Development Facilitation Team (DFT) – Review Comments

DRB Project No: PR-2020-004622 Date: 04/05/2023 Agenda Item: #3 Zone Atlas Page: L-15

Location: 1401 GIBSON BLVD SE

Application For: SI-2023-00592-SITE PLAN ADMINISTRATIVE (DFT)

SITE KEYNOTE PLAN

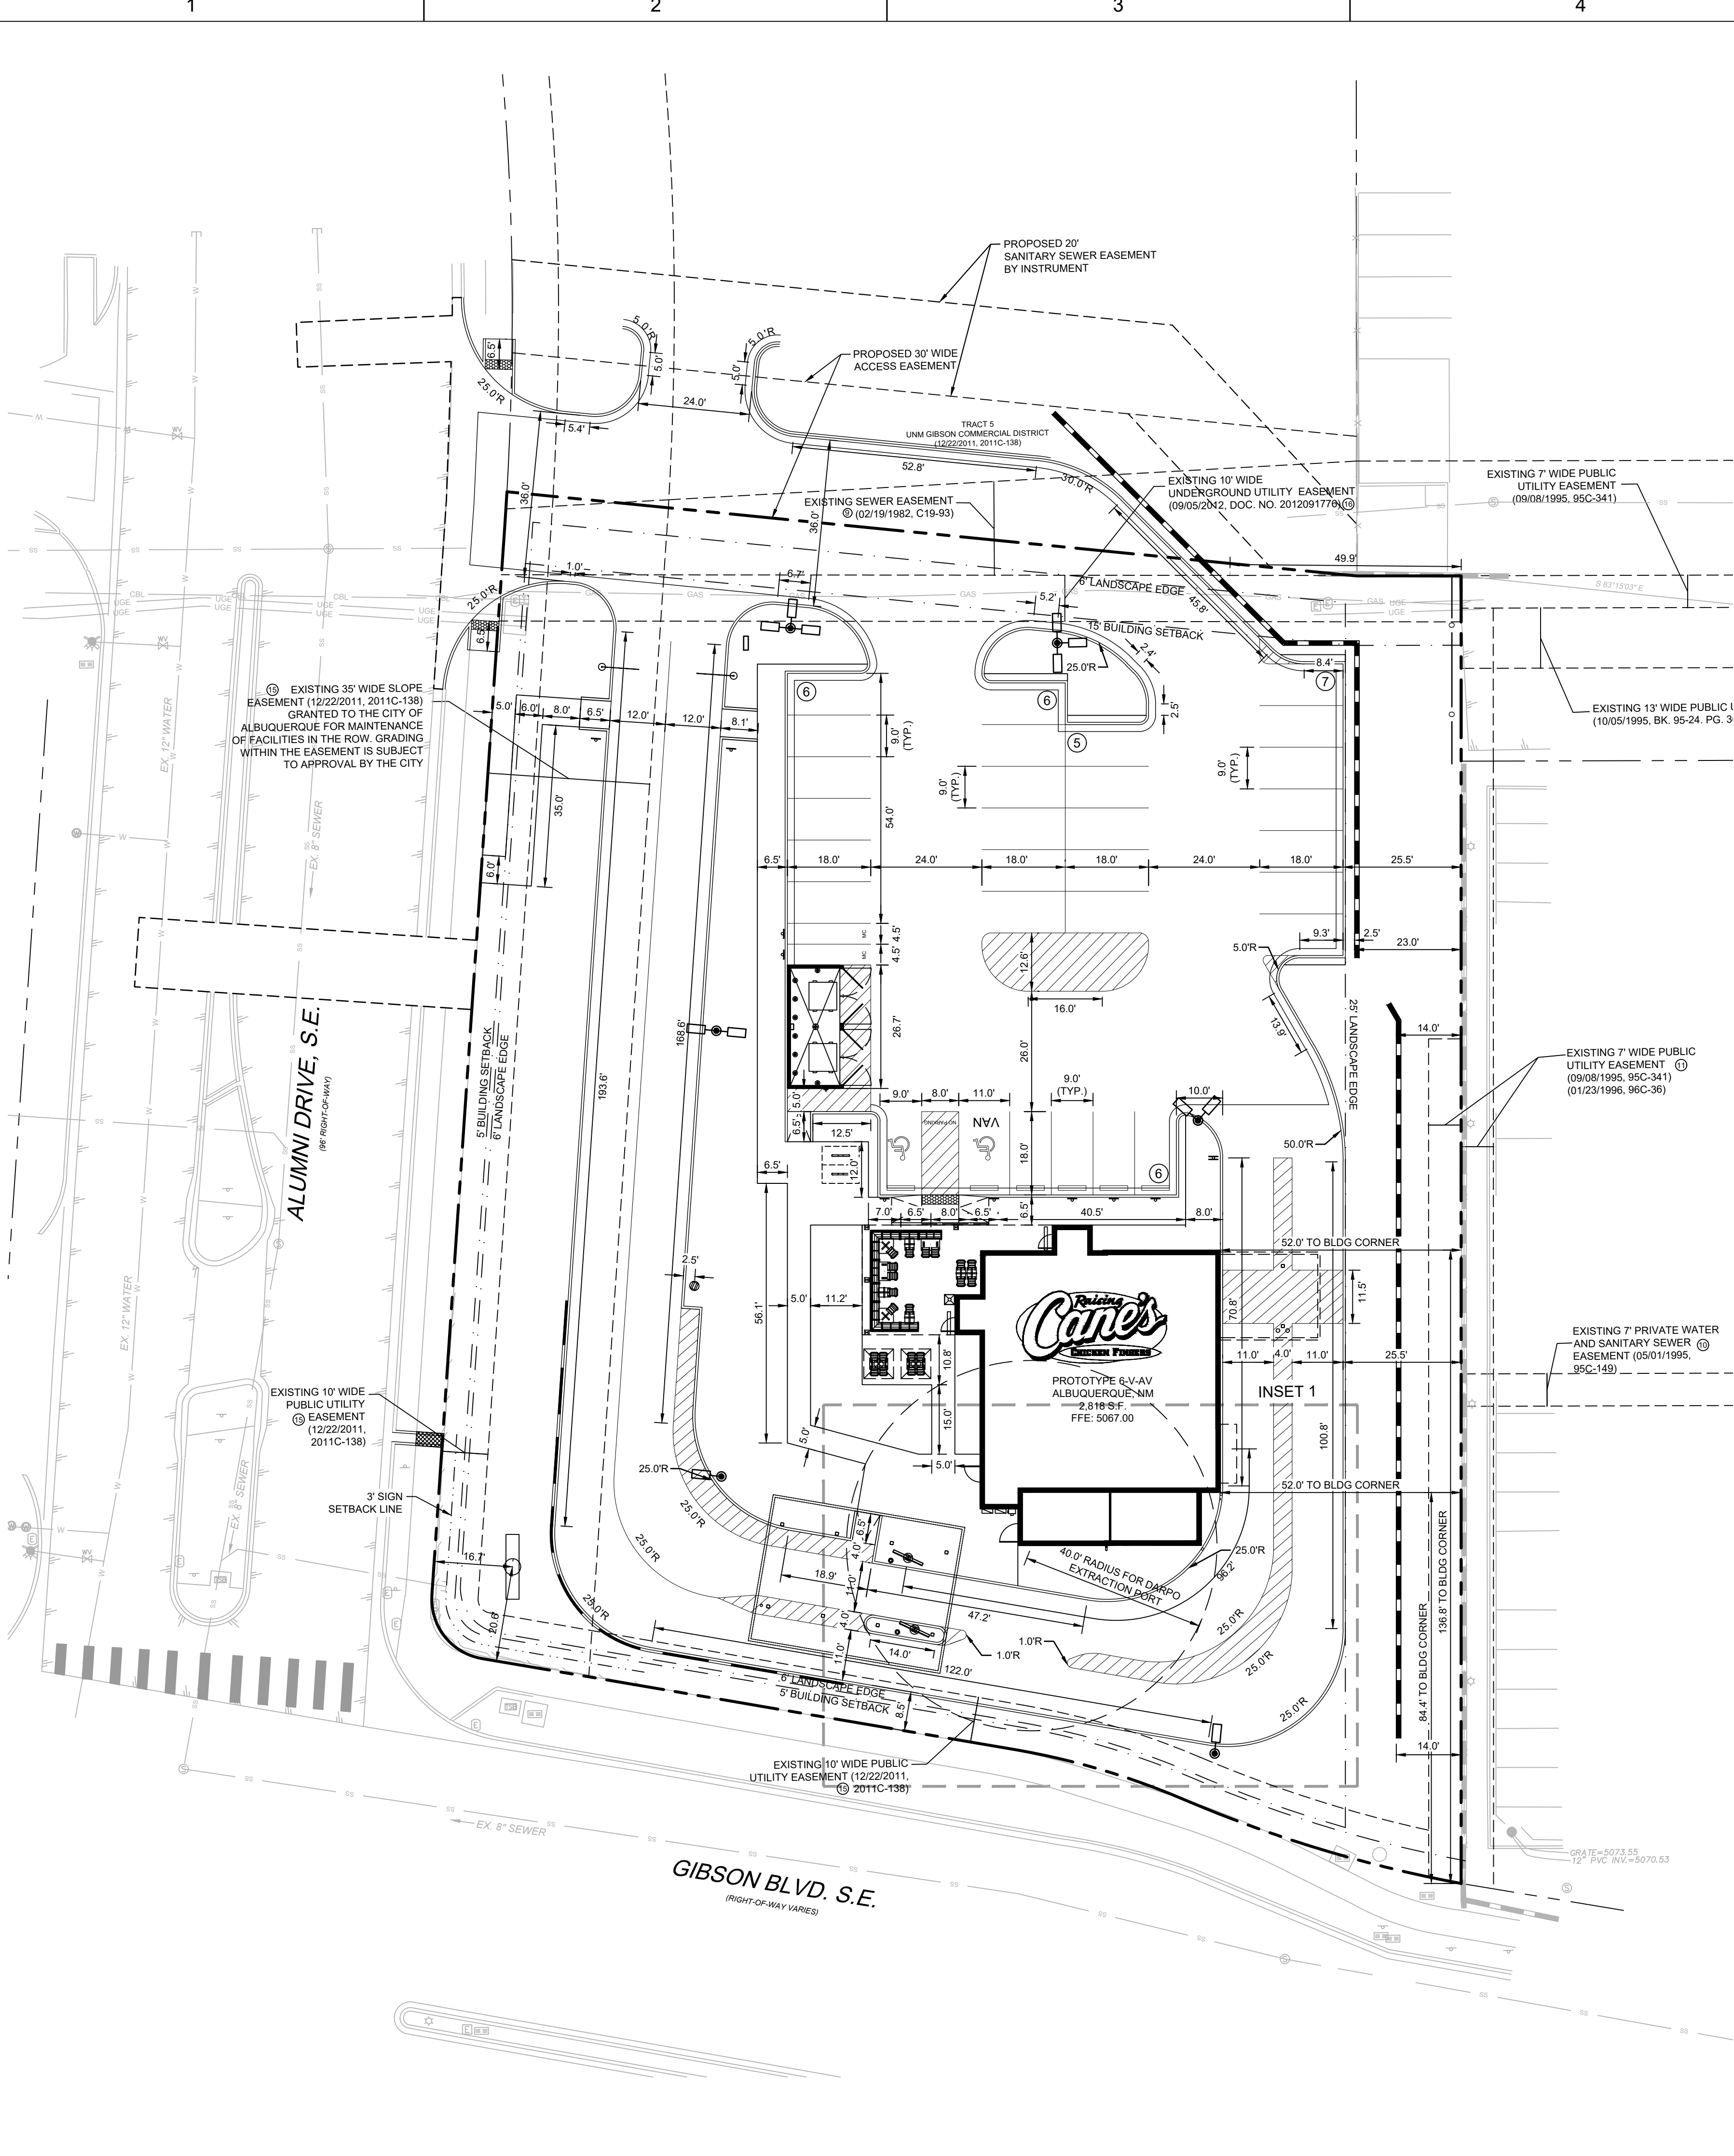
- **Check for and demonstrate compliance with section 7 of the DPM, Table 7.2.29, regarding Sidewalk width requirements and its landscape buffer. Identify widths of sidewalks and landscape buffers on the Site plan.**

Requires 6 ft Side walk and 4 ft-6ft Landscape Buffer.

Requires 5 ft Sidewalk and 4 ft-6 ft Landscape Buffer.

PRIVATE UTILITY PLAN

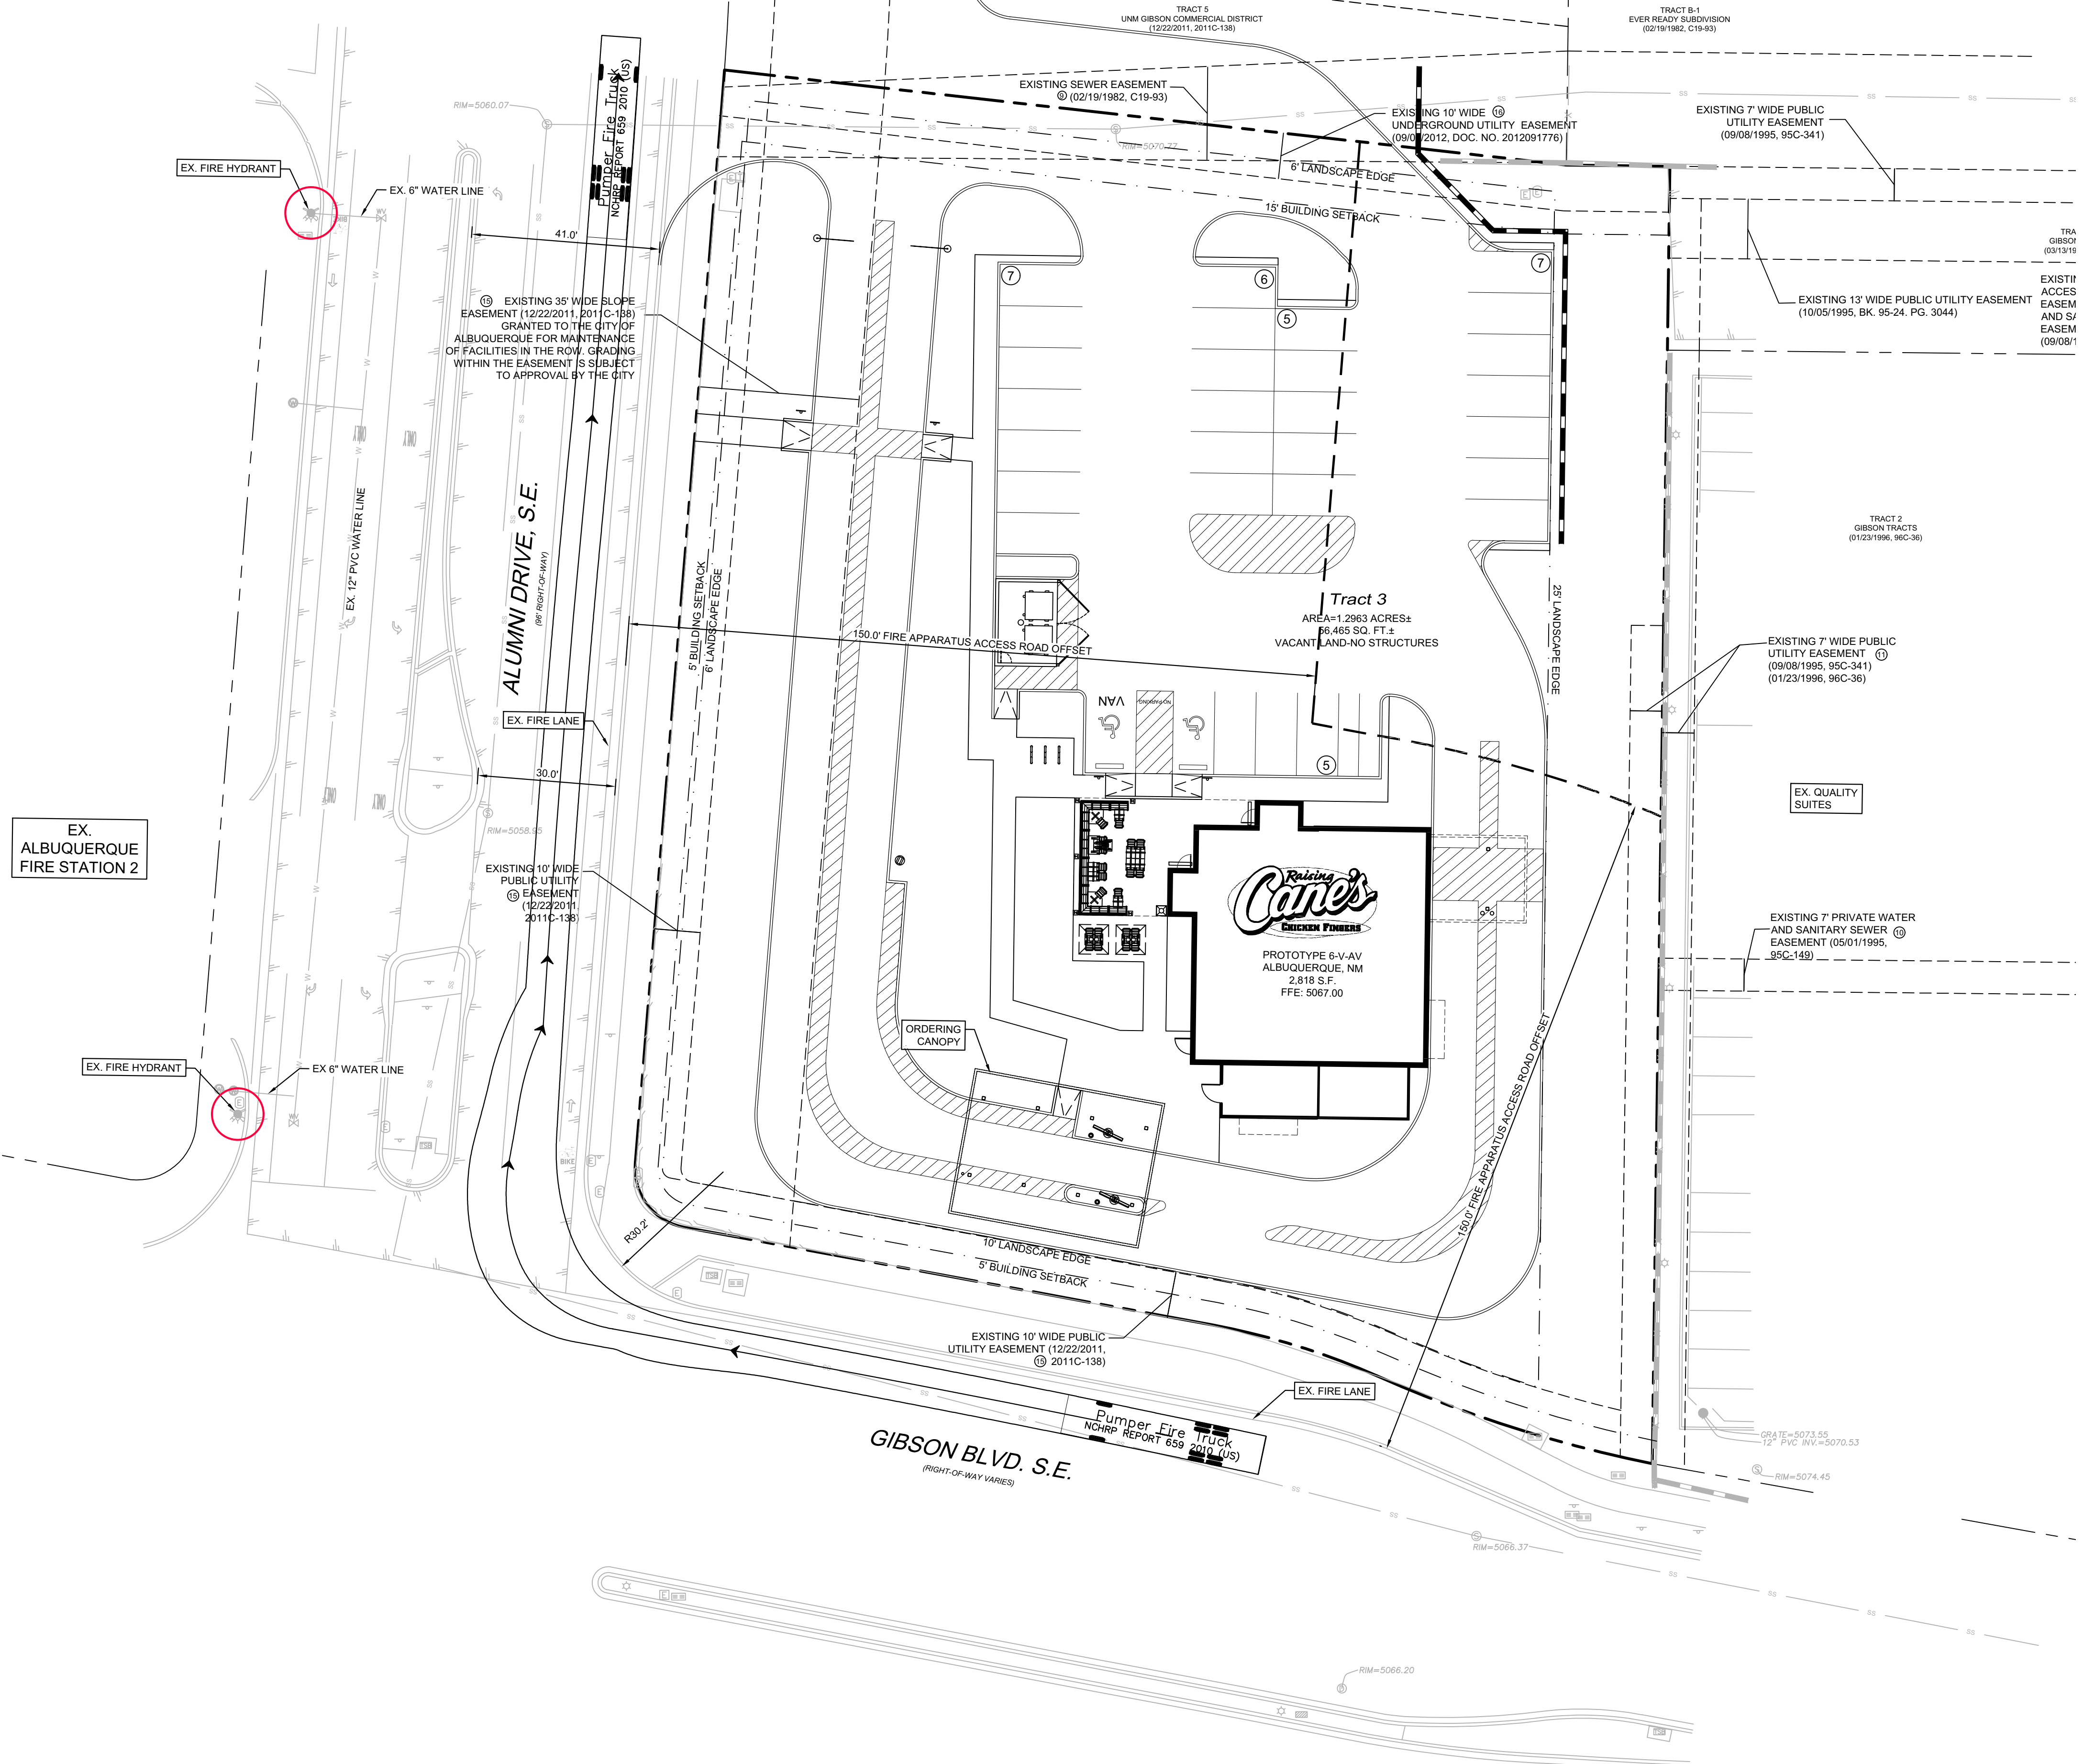
1. Clearly delineate private vs. public infrastructure on the site utility plan.
2. Please note that all off-site infrastructure will be constructed by other permit on the site utility plan.
 - a. Construction notes should not be placed on this plan where a separate permit will be utilized to avoid confusion or improper guidance as this is not approving the work within Alumni Drive at this time.
 - b. I see a note for a DRC project number. Will this go through a work order?
3. Infrastructure List:
 - a. It is not clear why there is removal of infrastructure and installation of infrastructure within Alumni Drive on the IL for sanitary sewer manholes and 8" line.
 - i. Is this public? Private?
 - b. Infrastructure is not required to be in the IL can can be completed with a connection permit if the City is in agreement as any cuts within Alumni Dr. will be within City -right-of-way.
